**M54 to M6 Link Road**

**TR010054**

**8.8P(C) Draft Statement of Common  
Ground with Historic England**

February 2021

Location title: View south from the first floor of Hilton Hall
Camera model: Canon EOS 6D
Focal length: 50mm
Field of View: 65° (Horizontal)
Camera height: 1.6m
Photo taken: 02/08/2019
Coordinates: 395199, 305176
Elevation: 156m AOD

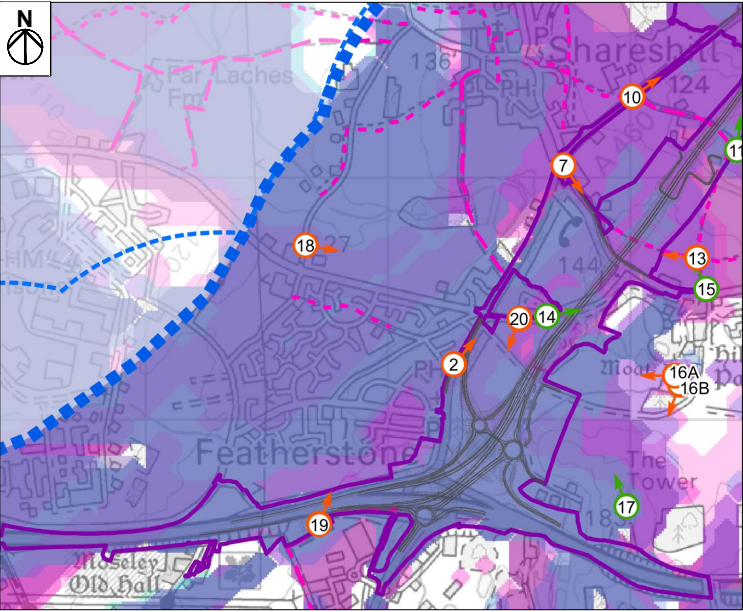
ES Chapter	Paragraph Reference	Sub-section	Historic England Comment	Highways England Response	Status	Agreement likely? <sup>1</sup>
			exception being further comments regarding Hilton Hall and the Conservatory; see the row below).		ry' which remain under discussion, see below).	
Chapter 6: Cultural heritage [APP-045/6.1]	Section 6.9 'Assessment of likely significant effects' Para. 6.9.12	Setting of Hilton Hall and the Conservatory	The parties agree that the setting of Hilton Hall and the Conservatory includes the entirety of Hilton Park. Harm to those assets caused by development within their setting will vary depending on the type of development and the location within the Park.		Agreed	Agreed
Chapter 6: Cultural heritage [APP-045/6.1]	Section 6.9 'Assessment of likely significant effects' Para. 6.9.12	Construction impact, Grade I listed building 'Hilton Hall'	Historic England query the assessment of impacts on Hilton Hall without it being evidenced that the Scheme would be screened from the hall by existing vegetation. The impact would be considered by Historic England to be at least moderate rather than minor ("Partial loss or alteration to a heritage asset's significance and/or its setting. Addition of new features that partially alter setting of a heritage asset to the extent where the significance is impacted.")  This assessment is based on the current condition of the planting on the west side of the Moat which is a lot more mature/	Viewpoint photographs Figure 6.5 and 6.6 [APP-076 and 077/6.2] illustrate current views from the hall and have been added to the ES to evidence this.  The quotation provided by Historic England is from a superseded version of the DMRB. The current criteria within the DMRB LA104 defines a minor impact as: "Some measurable change in attributes, quality or vulnerability; minor loss of, or alteration to, one (maybe more) key characteristics, features or elements."  With a moderate impact defined as "Loss of resource, but not adversely affecting the integrity; partial loss	Not Agreed	Not Agreed

ES Chapter	Paragraph Reference	Sub-section	Historic England Comment	Highways England Response	Status	Agreement likely? <sup>1</sup>
			<p>overgrown than intended in the original 19<sup>th</sup> century design.</p> <p>Historic England have subsequently stated that the area of concern is that while views may not be definitely affected, there is impact caused by changes within the park detracting from the parts of the hall's significance caused by its setting. They believe the impact to be greater than slight adverse. However, they do not believe the difference in impact levels to be very great, and it is agreed that the harm is less than substantial. Other options for the alignment here would have resulted in a greater level of impact on Hilton Hall.</p> <p>. Historic England have reviewed the photomontages and maintain their view that that the impact of the scheme on the Grade I listed Hilton Hall would be moderate.</p>	<p>of/damage to key characteristics, features or elements.”</p> <p>All assessments undertaken as part of an Environmental Impact Assessment as reported in the ES are based on the current baseline, not what it was like in the past. It is not possible or accurate to assess the magnitude of impact on what it was like in the 19th century.</p> <p>The assessment of effects on the hall has taken the impact of changes to the park into account. Only part of the park is affected. The impact on Hilton Park has taken into account impacts on individual elements of the asset such as Lower Pool and the Shrubbery as well as lesser impacts on other aspects of the parkland. It is our opinion is that the assessment should remain as slight adverse.</p> <p>A summer view photomontage was provided to Historic England on 4 November 2020. A winter view photomontage was provided on 1 February. Historic England and Highways England have agreed to disagree.</p>
